A30 Chiverton to Carland Cross

Statement of Common Ground with Nancarrow Farm

[Draft 2 – 19.03.19 – Nancarrow comments](#)

Drawing Title  
FIGURE 7.6 - ENVIRONMENTAL MASTERPLANS SHEET 10 OF 20

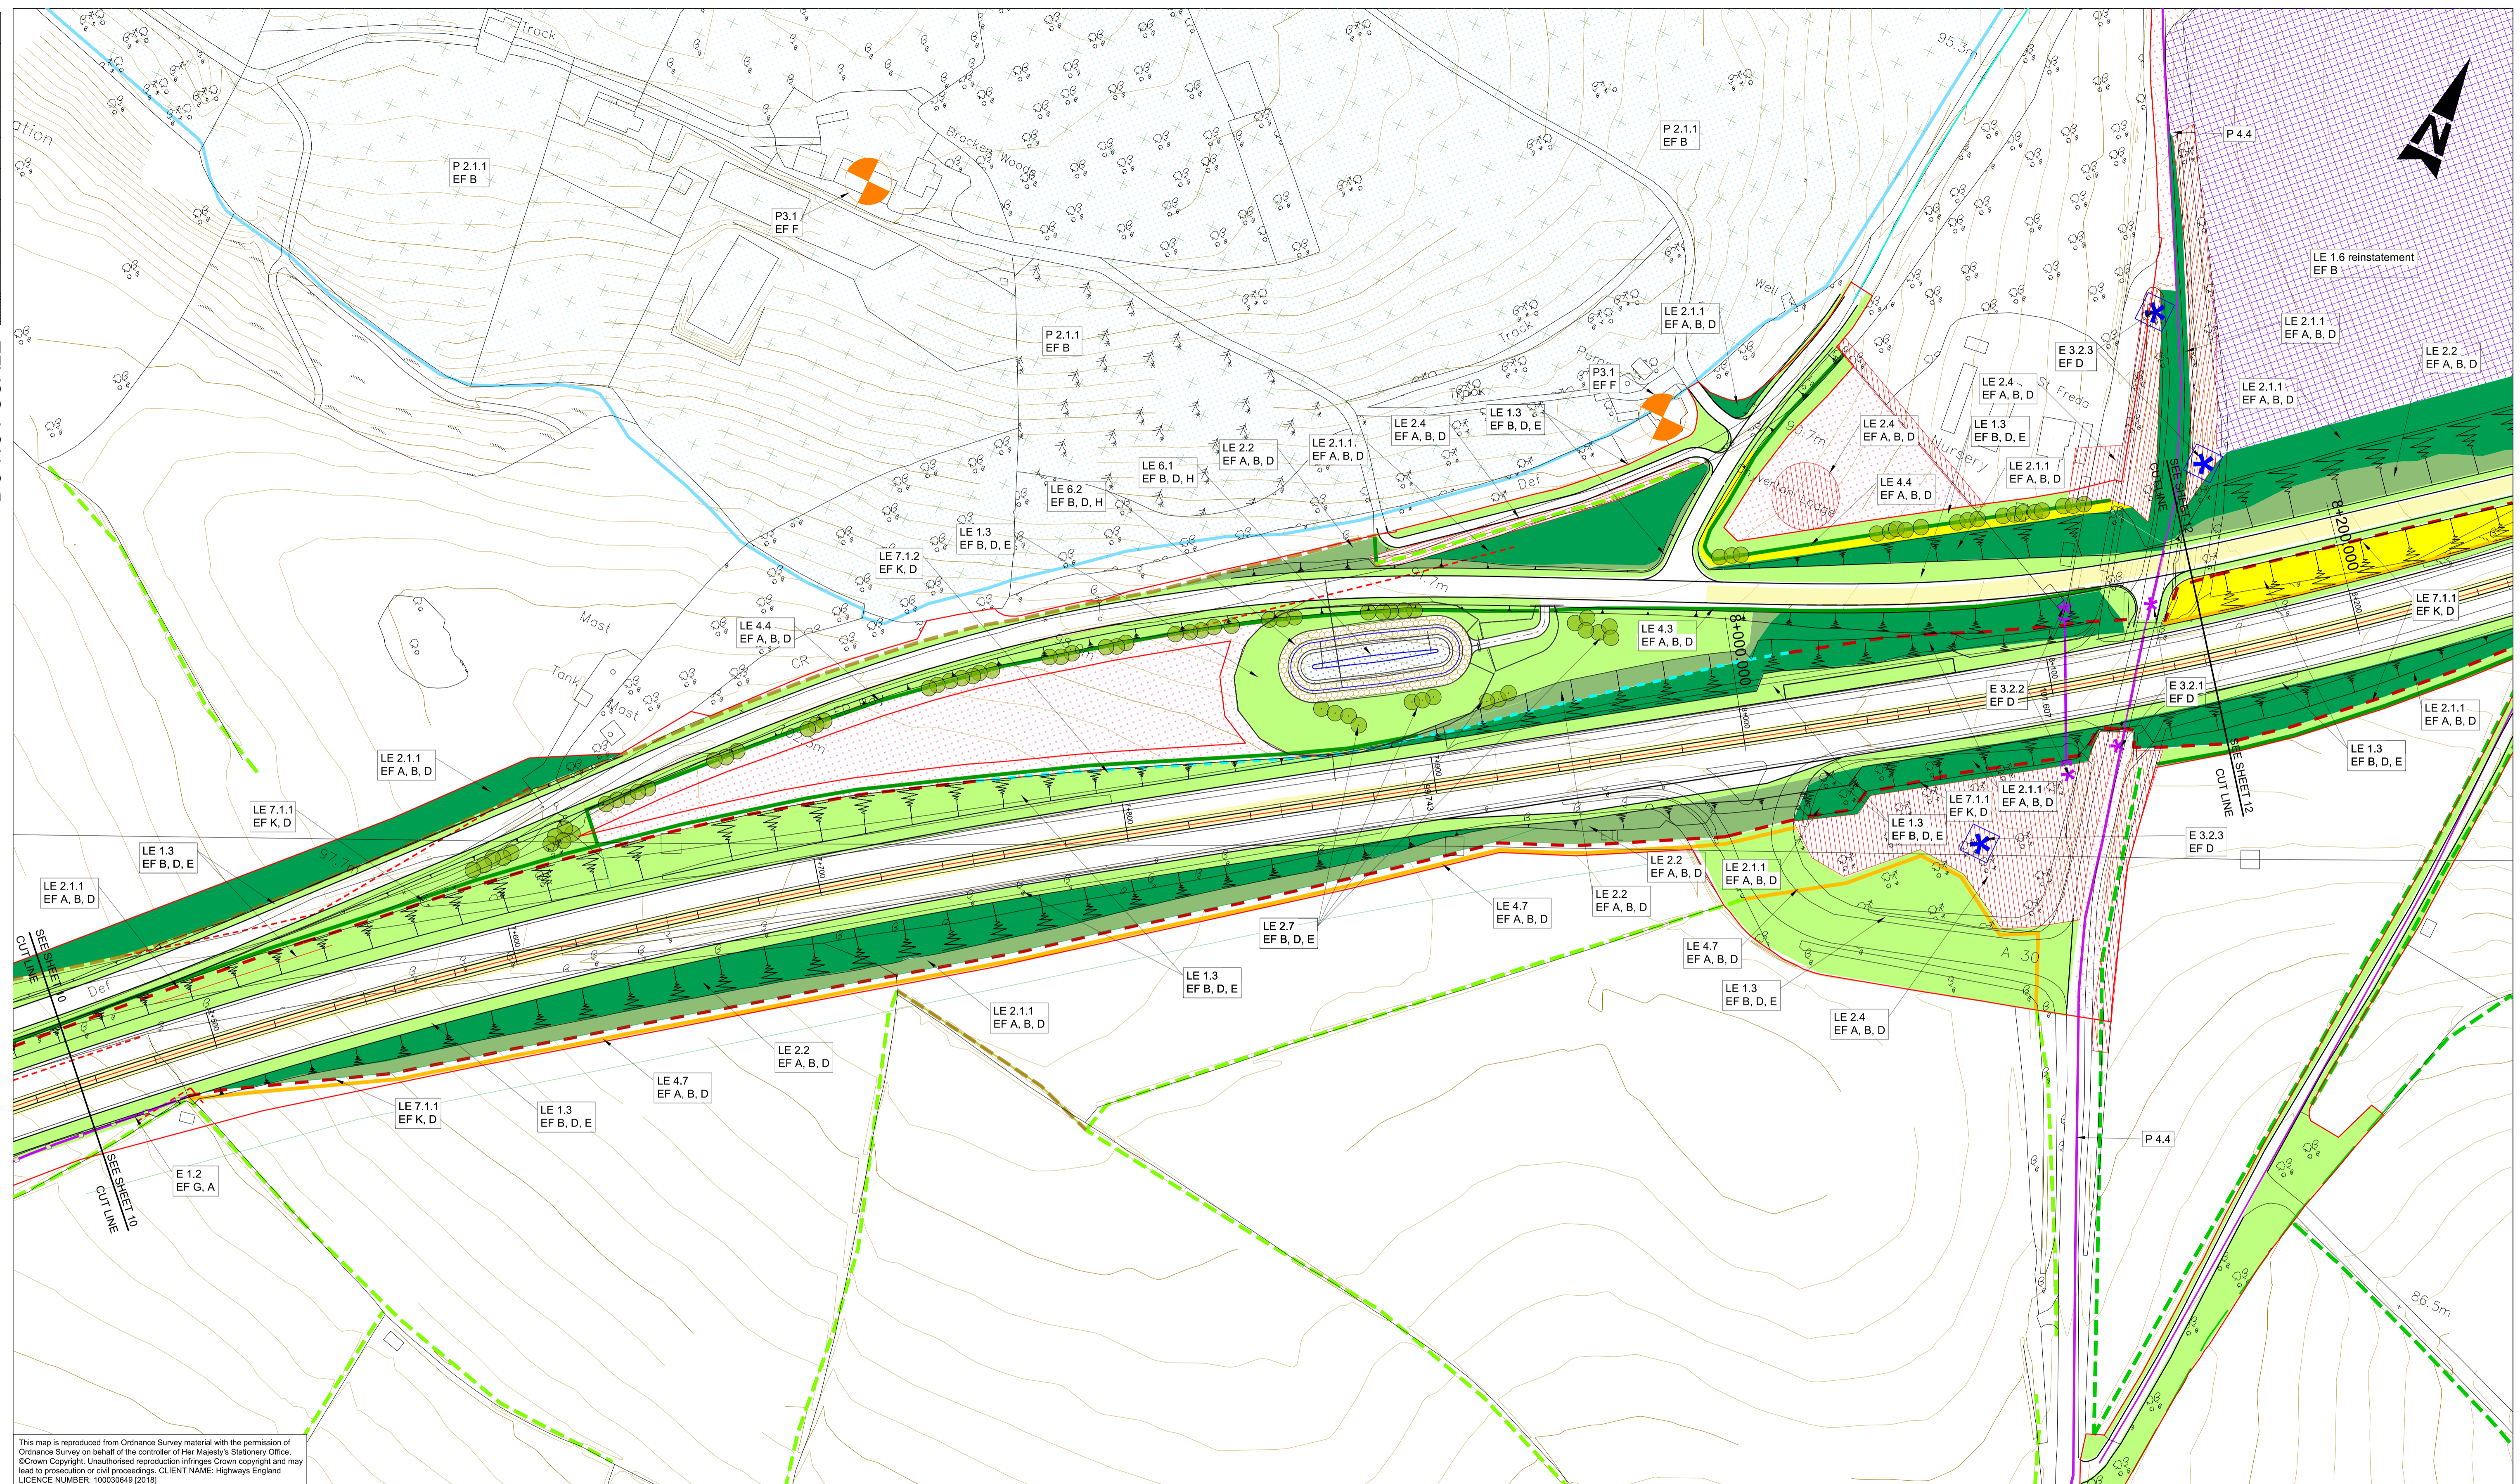
3.5	The existing mature oak rich field boundary to the south of Nancarrow Farm will be retained to filter views from the property to the site of the proposed attenuation pond. This is shown to the south of the scheme at Ch 7+140 on Sheet 10 of the Environmental Masterplans, Figure 7.6, (Document Reference 6.3).	Meeting held 07/06/2018

3.7	Specimen tree planting is proposed on the eastern end of the bridge embankment to replace the existing trees to be removed. This is shown at Ch 7+310 on Sheet 10 of the Environmental Masterplans, Figure 7.6, Document Reference 6.3.	Meeting held 07/06/2018

3.10	A new stock-proof timber post and three strained wire fence will be provided between the farm access track and the retained portion of the field to the south of the scheme at Ch+7110 to 7+290 (Sheet 10, Environmental Masterplans, Figure 7.6, Document Reference 6.3). <i>Any fencing included in the plan should be 'stock proof' featuring high tensile stock fencing (HT8030) with 2 strands of high tensile barbed wire. (3 strands of barbed wire is insufficient for sheep)</i>	Meeting held 07/06/2018

Drawing Title: FIGURE 7.6 - ENVIRONMENTAL MASTERPLANS SHEET 11 OF 20

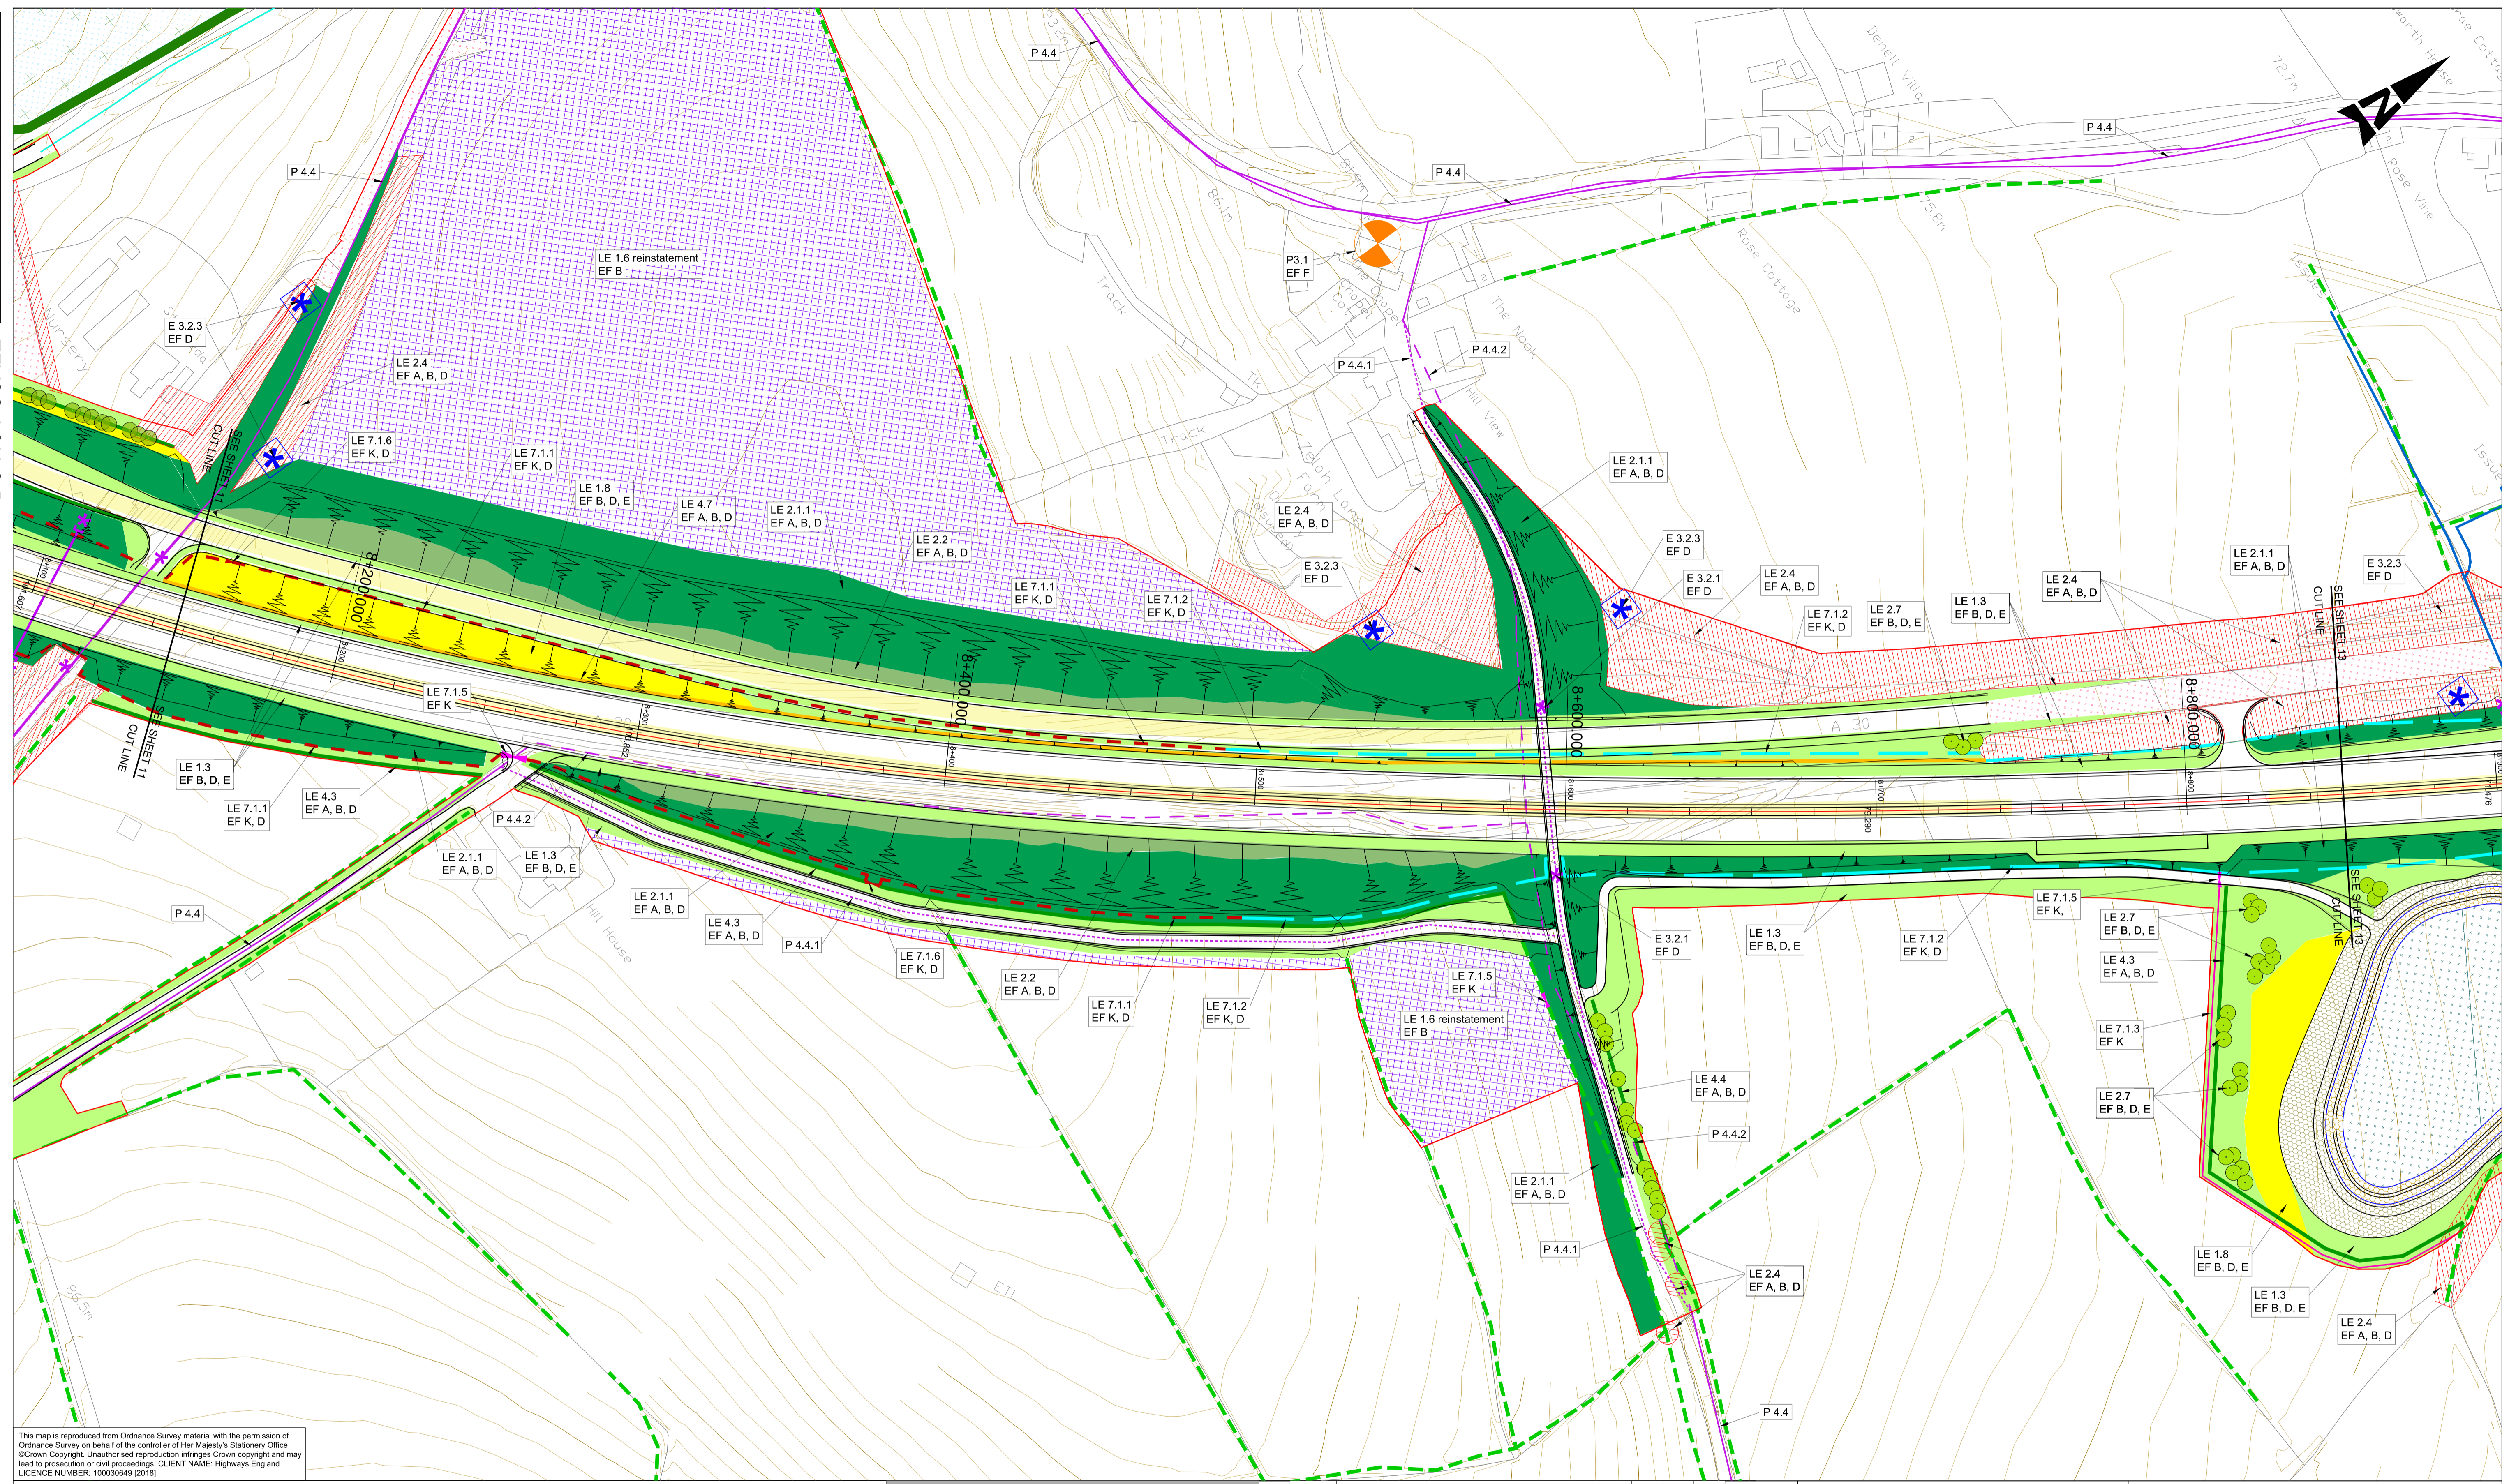
3.8	<p>The proposed Cornish hedgerow has been realigned following statutory consultation to retain corner boundaries of an existing field at Ch 7+320 to 7+550 (shown on Sheet 11, Environmental Masterplans, Figure 7.6, Document Reference 6.3).</p> <p><i>It had been agreed that damage to the existing field boundary could be avoided at chainage 7+400. This was confirmed via maps sent 21/06/19 and This is crucial to retain the historic field boundary, maintain visual screen from the Listed Farmhouse and Bridal Suite. We have not been notified of any changes to this plan but the latest drawing suggest otherwise. Please confirm asap.</i></p>	Meeting held 07/06/2018

3.9	It is proposed to break out and remove the road surface of the existing junction of the A30 with the C0089 (Ch 8,000 to 8,100, Sheet 11, Environmental Masterplans, Figure 7.6, Document Reference 6.3). This area will be made good with grading, top soiling and seeding and Cornish hedgerows to return to agricultural use. The existing island of woodland and scrub inside the junction would be retained.	Meeting held 07/06/2018

Reference	Matter which has been agreed	Date and method of agreement
	<i>This has not been discussed in any detail, but Nancarrow would welcome the opportunity to discuss this further.</i>
